LLFA PLANNING RESPONSE

Objection 1 – Surface Water Sustainable Drainage Strategy

7274-TRP-ZZ-XX-DR-D-4000 P05

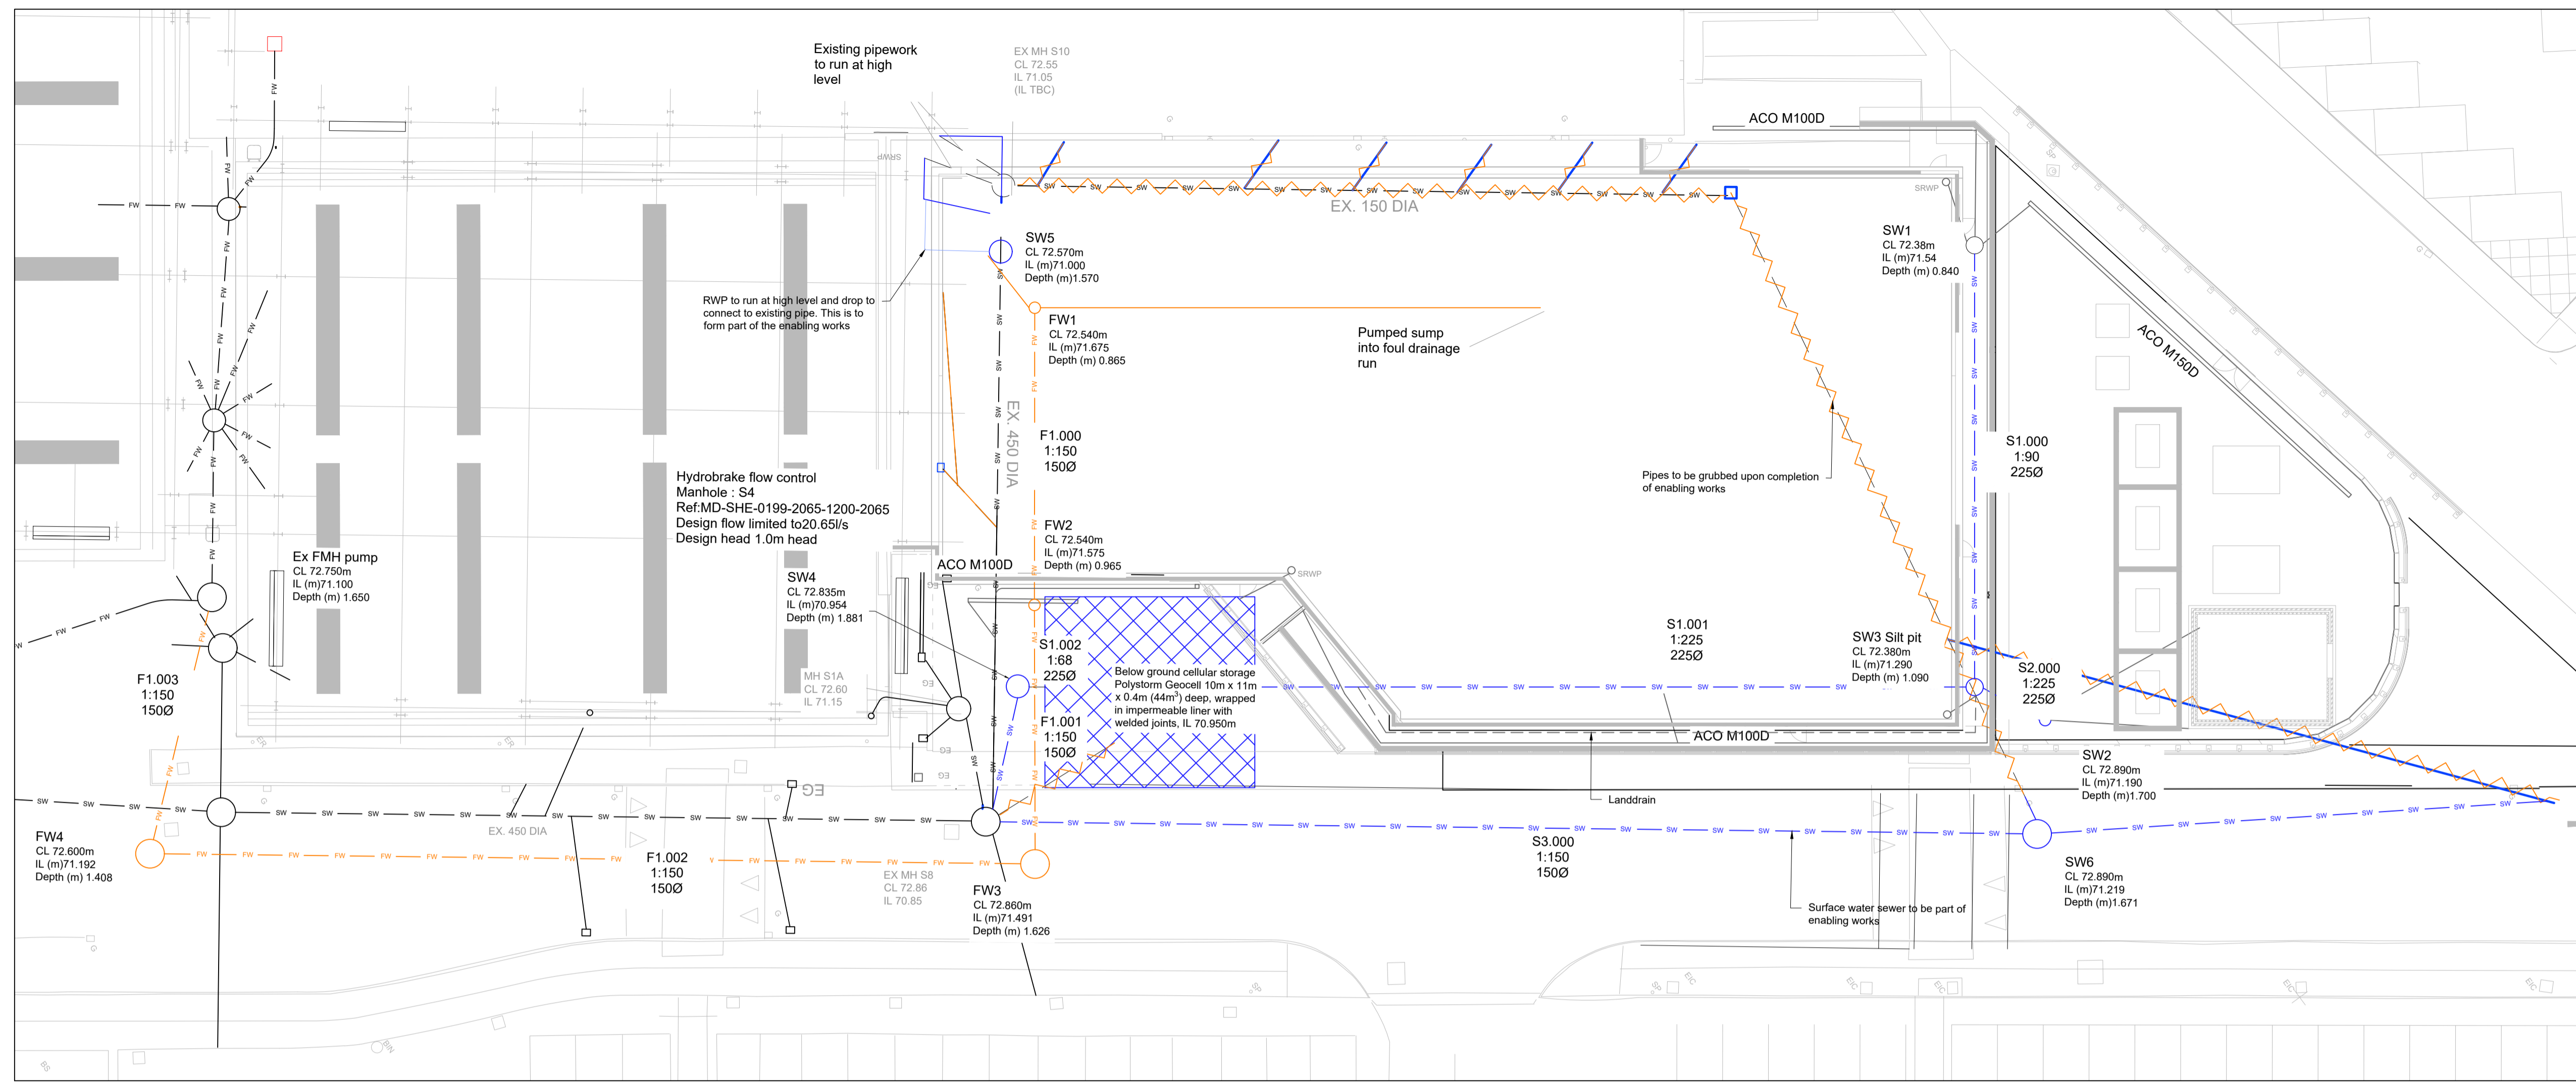
The LLFA has queried whether the proposed drainage strategy shows that post-development peak flow rates will not exceed pre-development rates for the 1 in 1-year and 1 in 100-year events.

The LLFA has also asked for more evidence that runoff volumes for a 1 in 100-year, 6-hour event have been limited to a level reasonably close to greenfield and do not exceed pre-development discharge volumes.

We have modelled existing and proposed surface-water flows using InfoDrainage for the 1:1, 1:30 and 1:100-year rainfall events, in line with Point 1 of Section 24.5 of the SuDS Manual (C753). The results show:

- 1 in 1-year event: pre-development 18.9 l/s; post-development 4.9 l/s (around 75 % reduction).
- 1 in 100-year event: pre-development 56.5 l/s; post-development 22.5 l/s (around 60 % reduction).

These figures include both central and upper-end climate-change allowances (see table below). They demonstrate that peak discharges after development are substantially lower than existing flows and therefore satisfy Defra Technical Standards S2 and S3 as well as NPPF paragraph 169.

The current site is 100 % hardstanding. The proposed development will be about 70 % roof and the remainder hardstanding. The table above shows the pre- and post-development discharge volumes for a 1 in 100-year, 6-hour event:

- Without climate-change allowance, pre- and post-development discharge volumes are broadly similar.
- With the central allowance, the additional volume is 38.03 m³, which over 6 hours equates to 1.75 l/s—below the widely used greenfield limit of 2.0 l/s (UKSuDS and Rainfall Runoff Management for Developments guidance).
- With the upper-end allowance, the additional volume is 54.33 m³, equating to 2.52 l/s compared to pre-development.

The extra volume will be contained within a 44 m³ cellular attenuation tank. Existing runoff is simulated at 29.5 l/s; applying a 30 % betterment gives a restricted flow of 20.65 l/s through a hydrobrake. While full compliance with Defra Standard S5 cannot be achieved under climate-change allowances, the strategy meets Standard S6: central-allowance discharges are below 2.0 l/s and upper-end allowances only slightly exceed this limit. On this basis, the development is not expected to increase downstream flood risk.
